Engineers Comments Regarding Surface Water Drainage

APPLICATION NO: LU/48/20/PL

Site Address: Southdown Nursery Old Mead Road Littlehampton BN17 7PU

Description of Works: Demolition of 1 No. bungalow & outbuildings & erection of 22 No. dwellings with associated parking & open space. This application is a Departure from the Development Plan.

DRAWING TITLE
Proposed Site Layout Plan

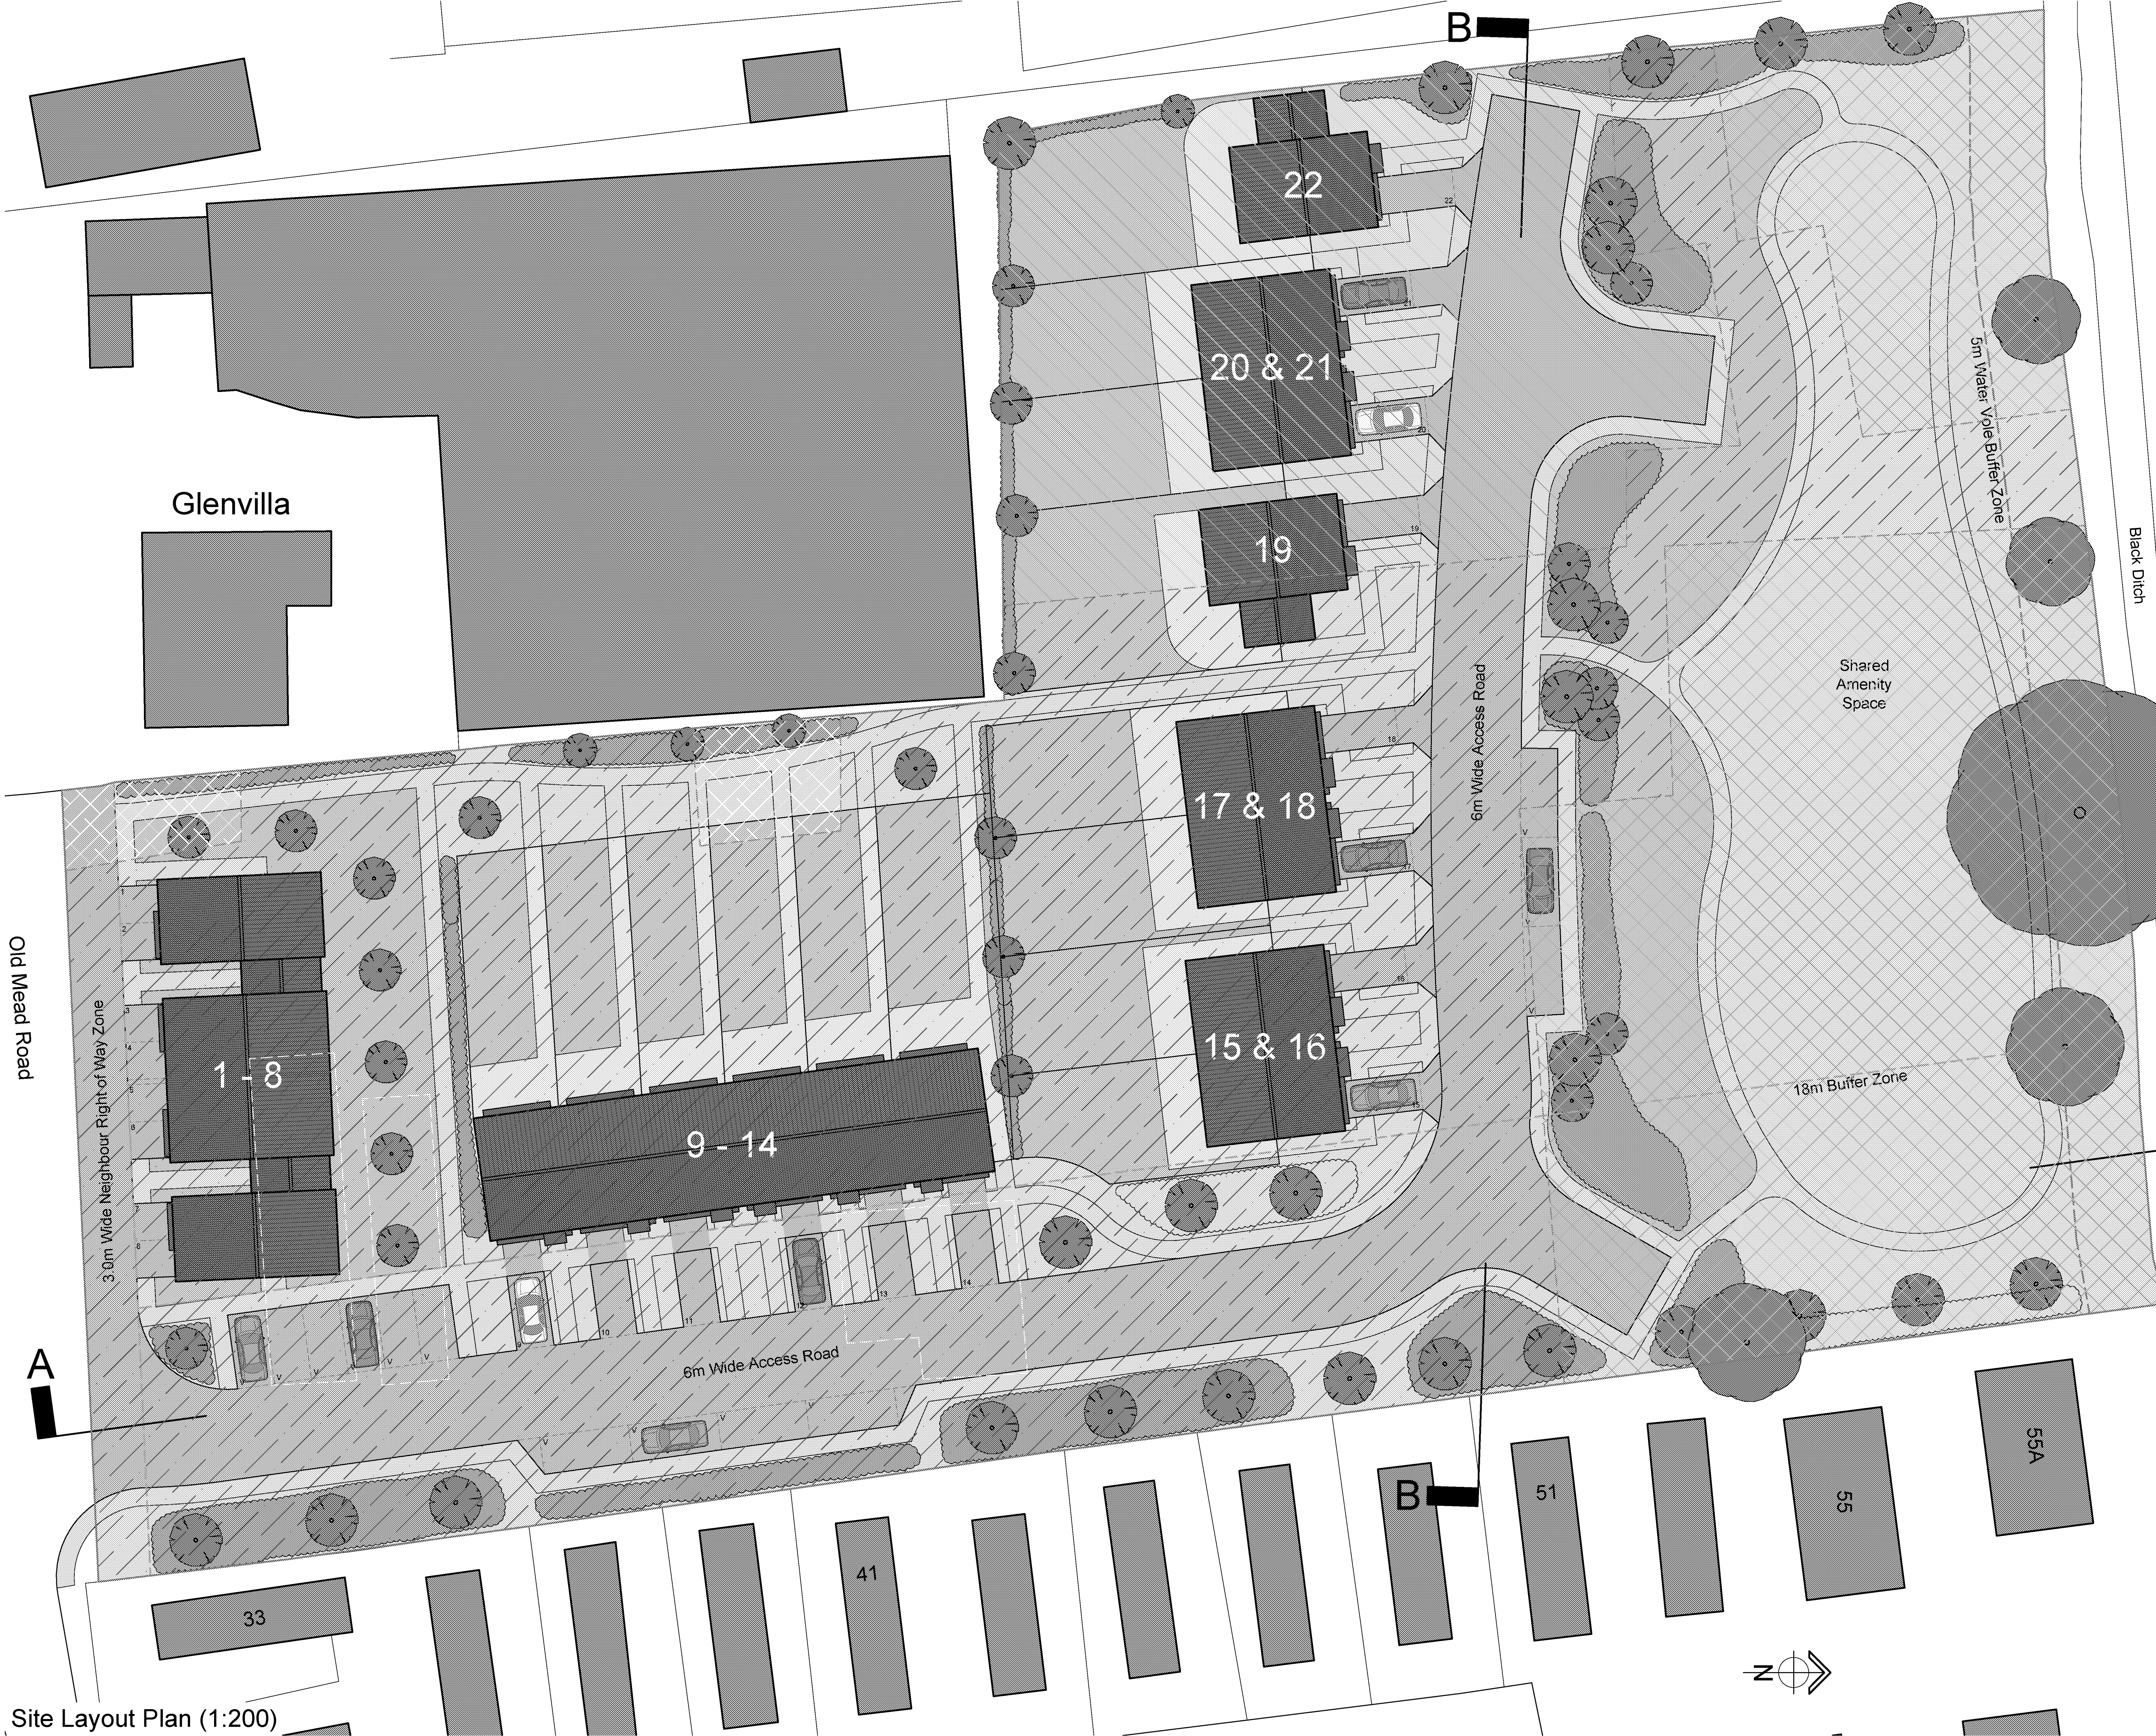
1. According to our records this site lies entirely (not partly) within Flood Zone 3. The applicant is proposing to attenuate surface water (suds) in a dry basin and geocellular crates located in the northern section of the site within functional flood plain (Flood Zone 3b). No attenuation of surface water should occur within the flood plain, and any fluvial/tidal floodwater must not have a detrimental impact on the suds design in any way. It is unclear how the applicant will be able to achieve this, whilst also ensuring that all property is not within flood plain.

3. Please note that the calculations provided account only for the rainfall emanating from the roads and roof areas, the basin itself will also need to be accounted for (rain fall directly to the open location). In addition, it is unclear whether the basin comprises the flood compensation for the development. Any storage of surface water provided by attenuation must be in addition to the volume set aside for flood compensation.

4. SuDS features will also not contribute to the open space allocation, it is unclear what area is designated as the public open space for the site. Please consult Parks and Greenspace for an opinion on this.
